Goulburn Mulwaree Council
Locked Bag 22
Goulburn NSW 2580

17 November 2021

Subject: Gunlake Quarry Continuation Project (SSD 12469087)

A review of the Environmental Impact Statement prepared by EMM Consulting has been undertaken in relation to the above proposal and a report was considered at the 16 November 2021 Council Meeting. At this meeting, Council resolved:

## Culvert widening concept drawing

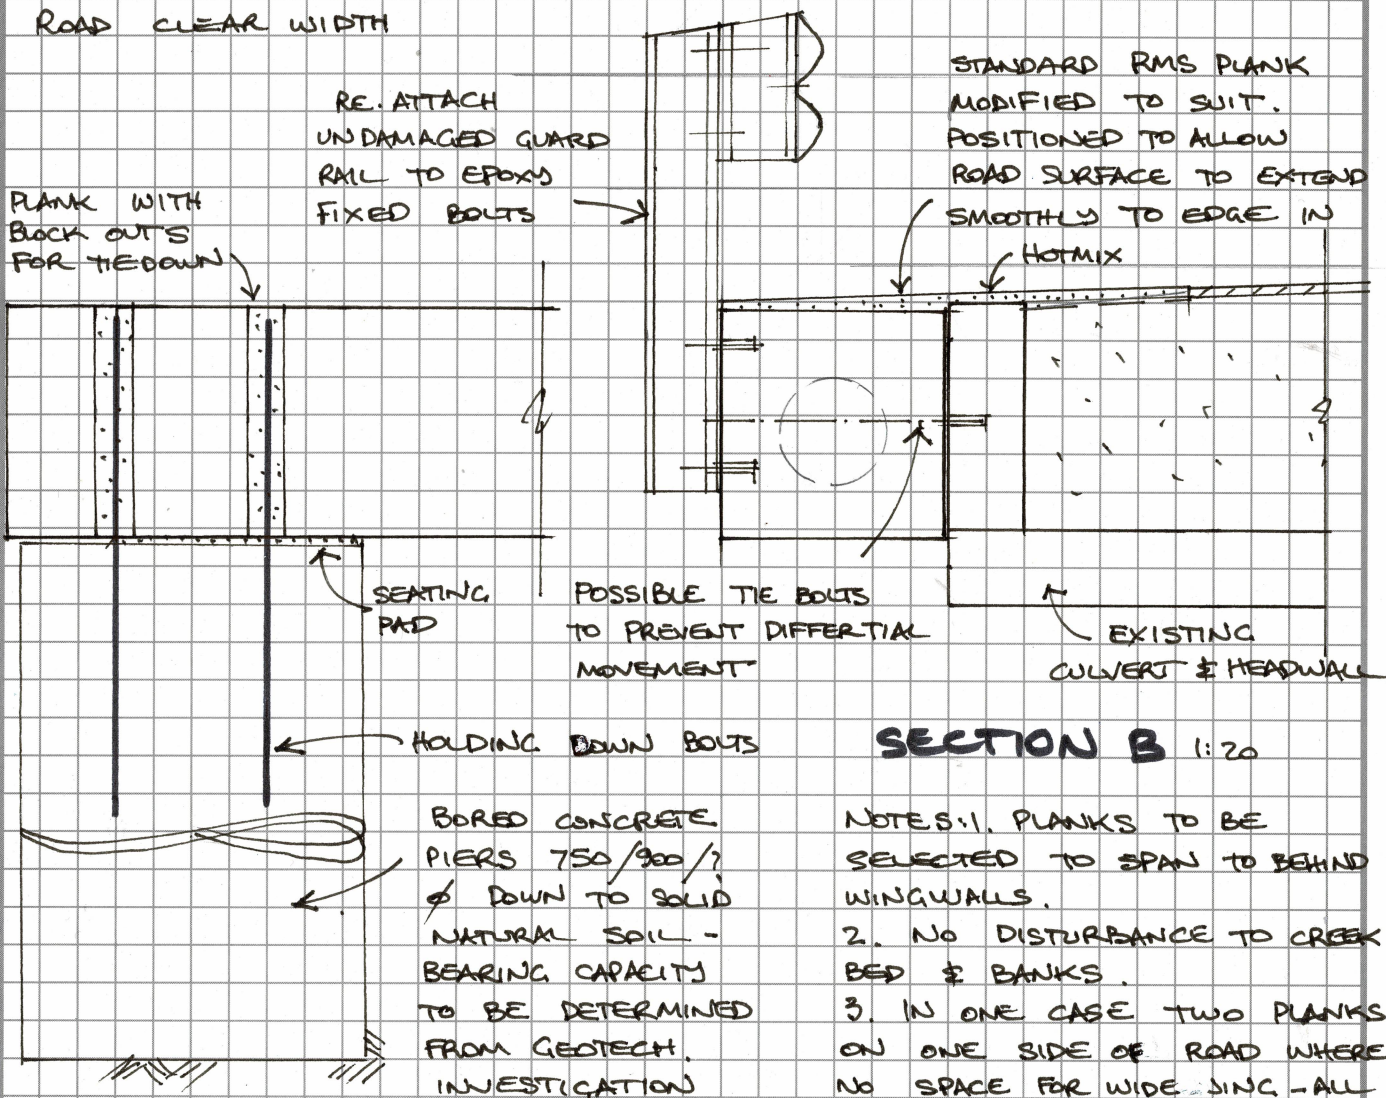
- ii. Widening of bridges and culverts is required on the primary transport route to allow a consistent wide centre line treatment to be implemented.***

**FIGURE 5 – Lines of sight for light vehicle drivers exiting Red Hills Road**

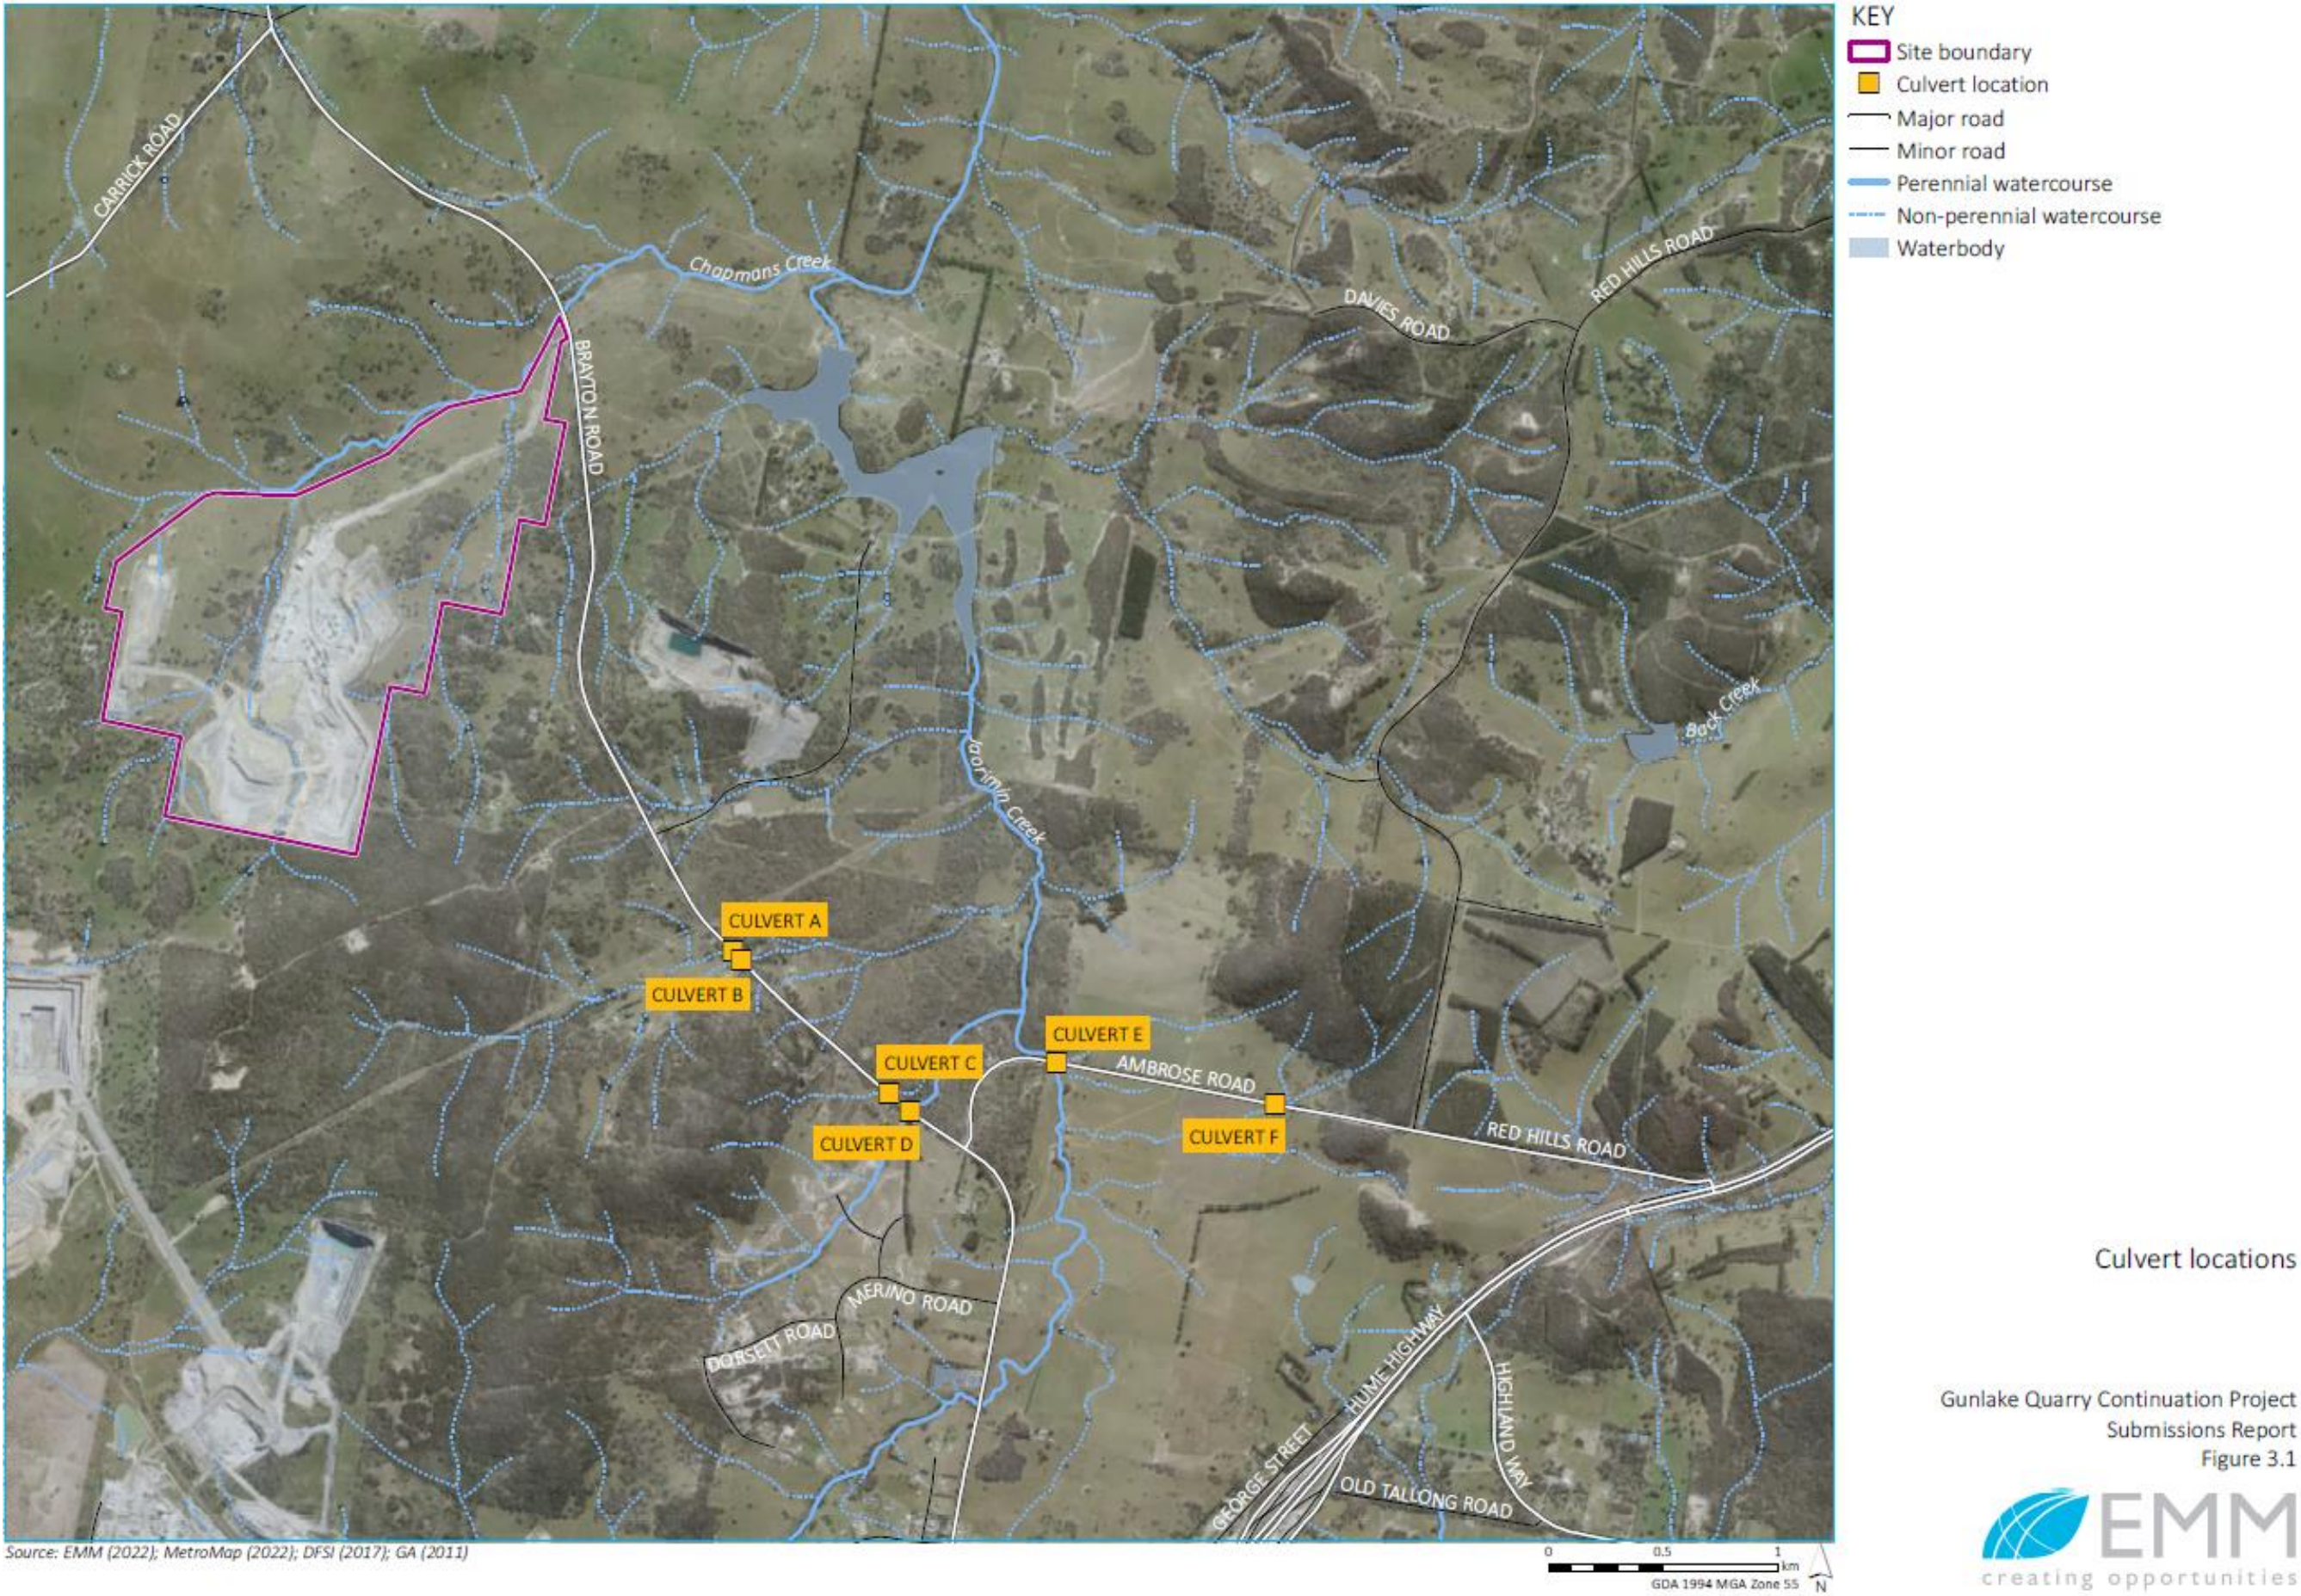
- v. The intersection of the Brayton Road and Ambrose Road intersection should be assessed to ensure it meets the relevant Austroads Guidelines,***
- vi. The sight distance be reviewed at the intersection of Red Hills Road and Ambrose Road for vehicles existing Red Hills Road. If improvements are identified by the review they be implemented in accordance with Austroads Guidelines.***
